DEVIATION REQUEST AND DECISION FORM

Project Name : Crossroads North

DEVIATION REQUEST (Attach diagrams, figures, and other documentation to clarify request)

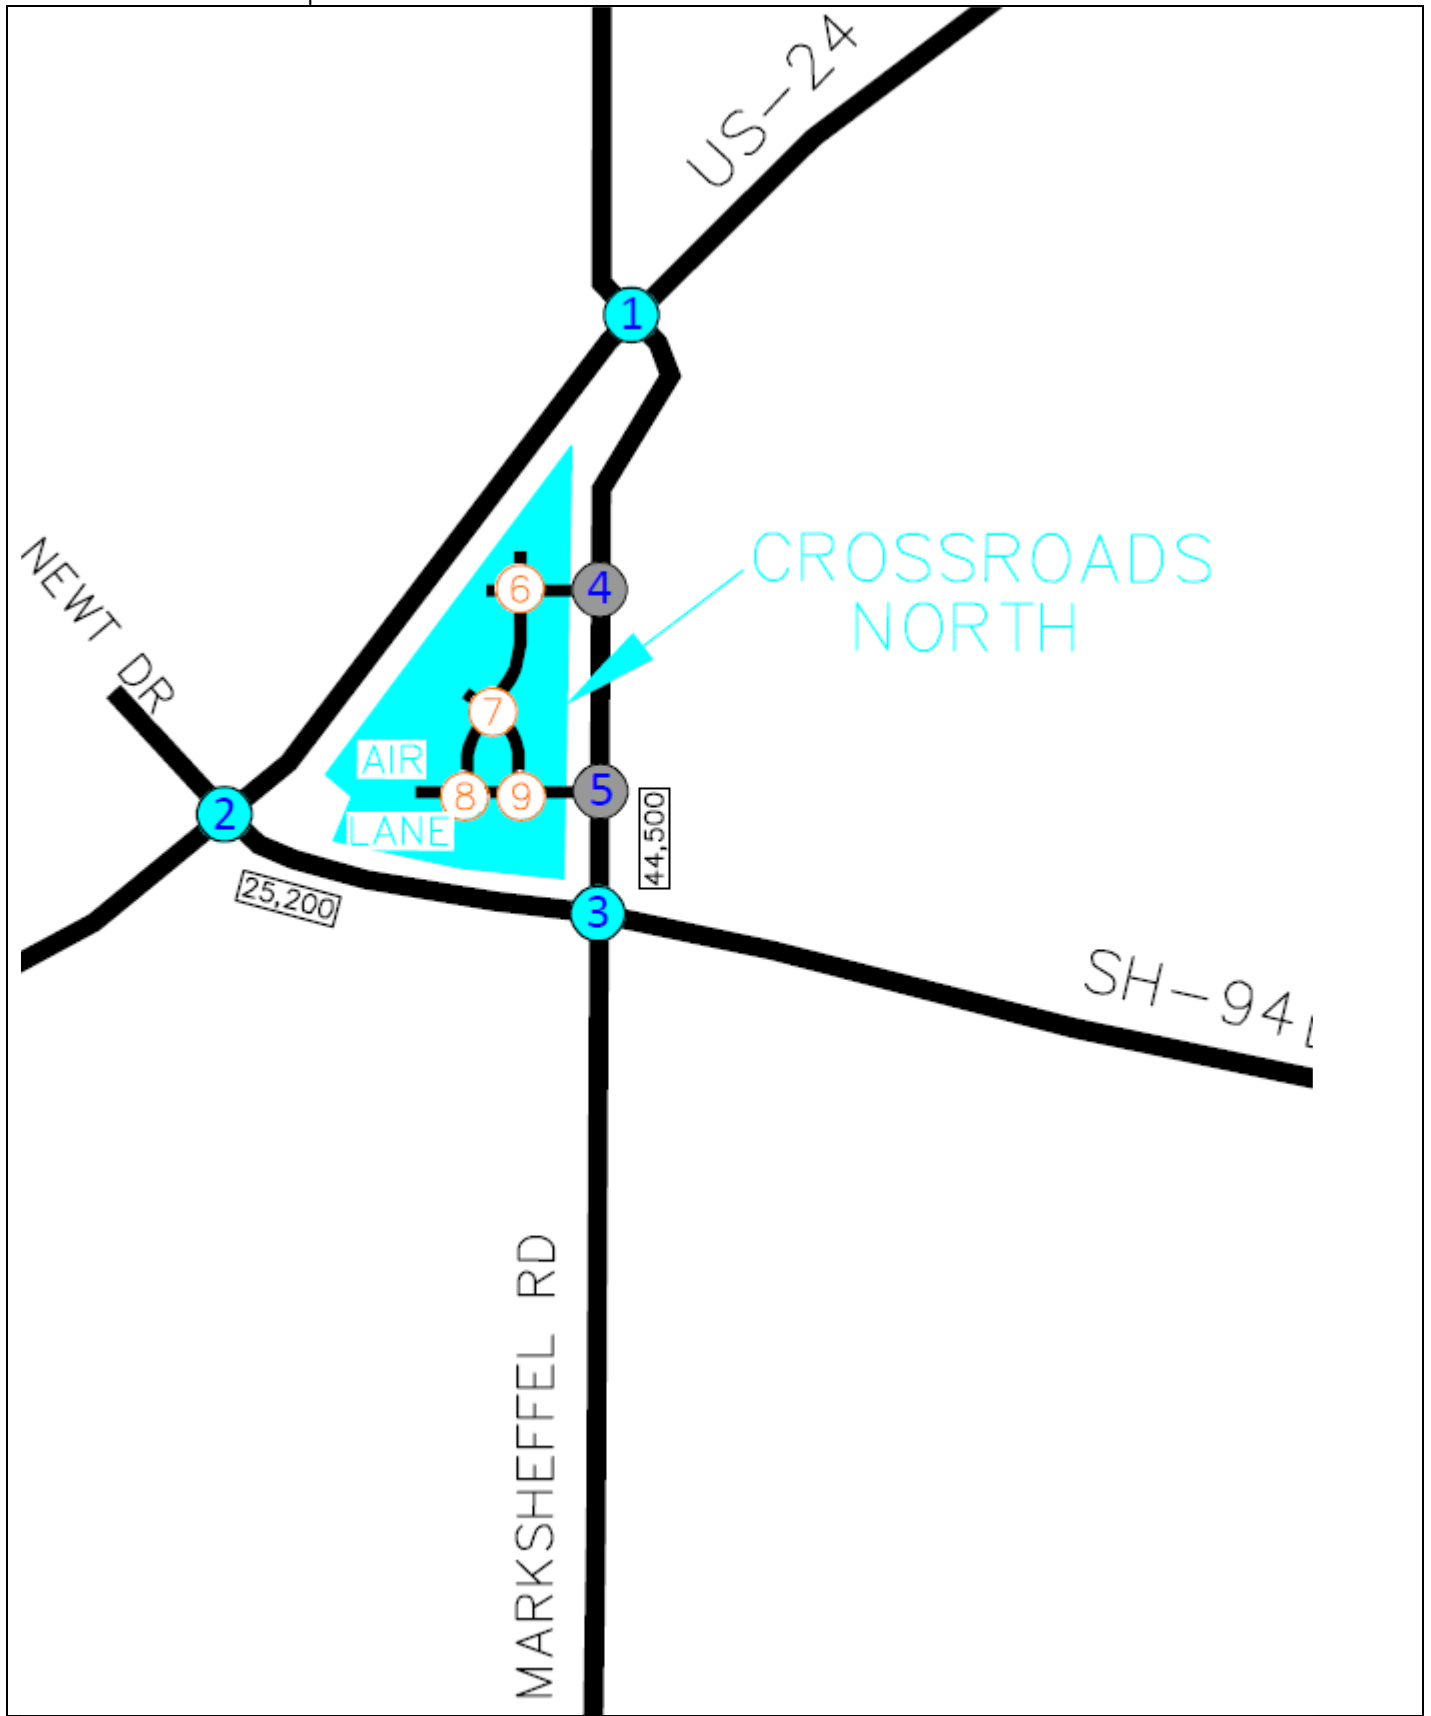
Deviation request will be denied based on City of Colorado Springs comments to design the north access as unsignalized 3/4 movement. Staff recommend withdrawing the deviation request.

3/4 movement will not require a back to back left turns at this intersection (access #4)

The city of Colorado springs require the development to design the north proposed site access (access #4 in the TIA) as unsignalized 3/4 movements intersection, and the proposed south site access (access #5 in the TIA) as signalized full movement intersection.
